Permit Inspections Harnett County

Permit Number: **SFD2203-0071**

Site Address: **1390 COOL SPRINGS RD**

LIST OF INSPECTIONS

**FOUNDATION PLAN**

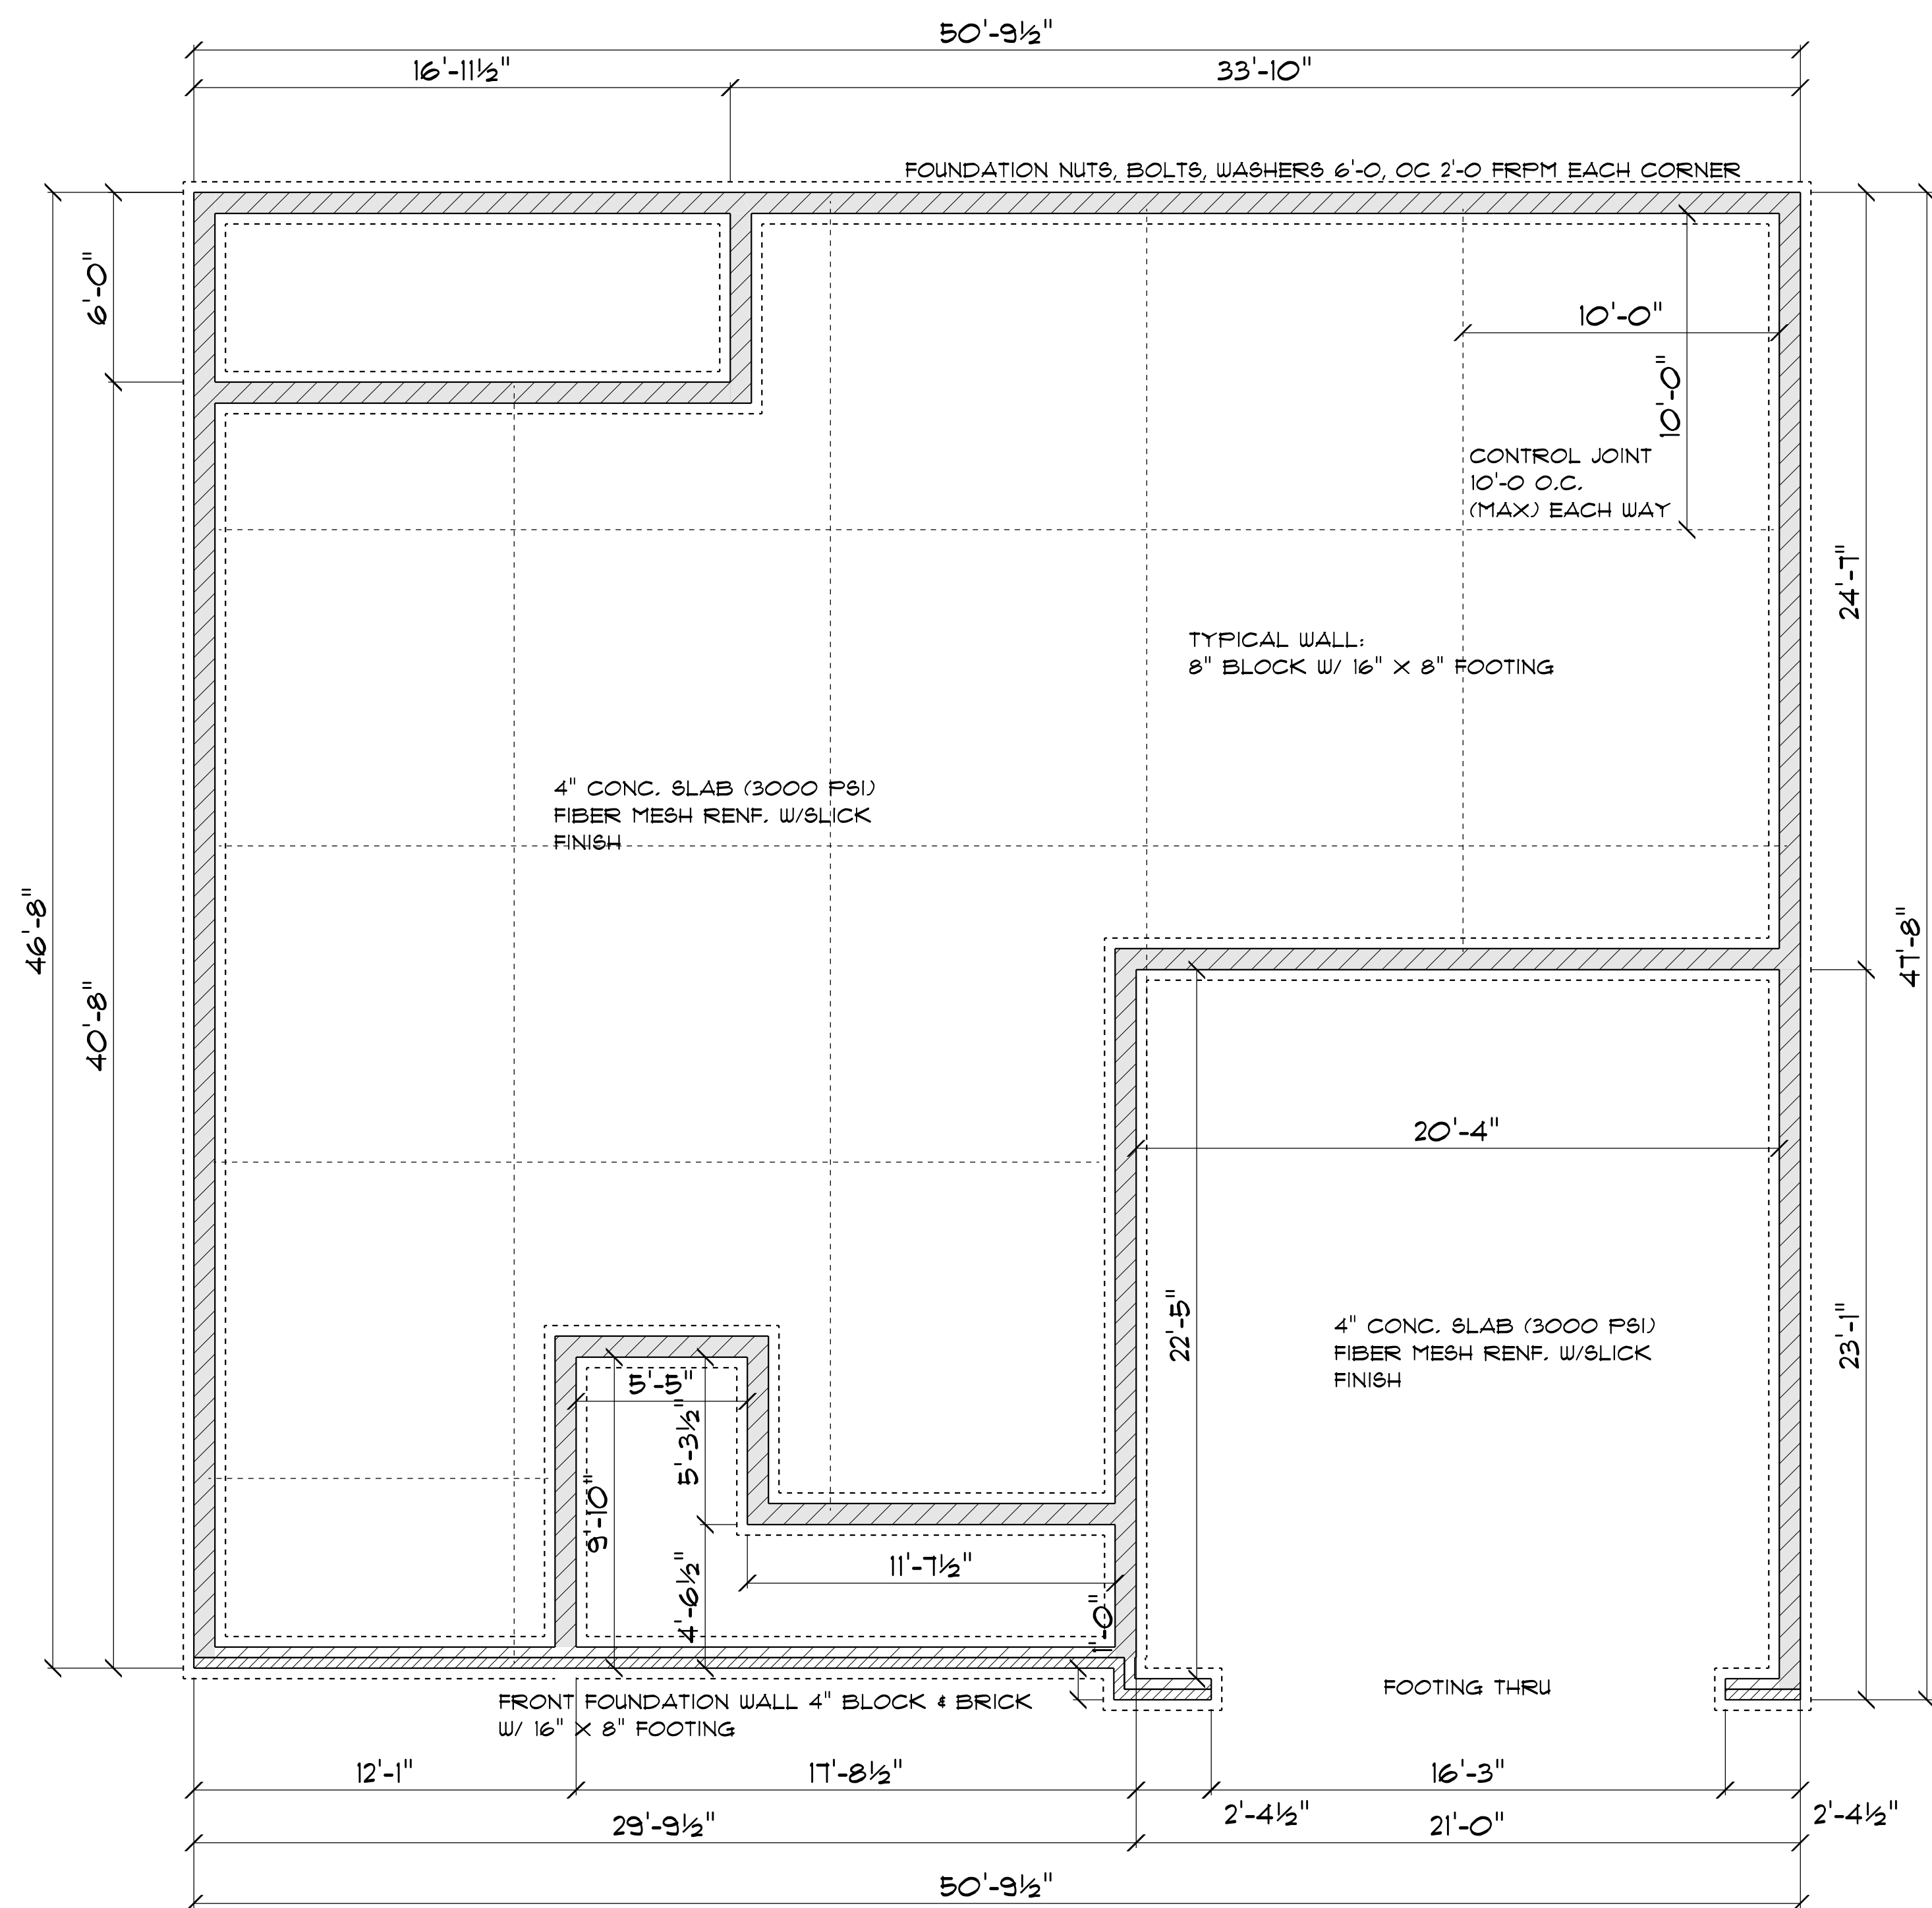
There was 2 sets on slab drawings on site. I used the drawings that where stamped from harnett county. Those plans didn't has a lug footing by the garage.
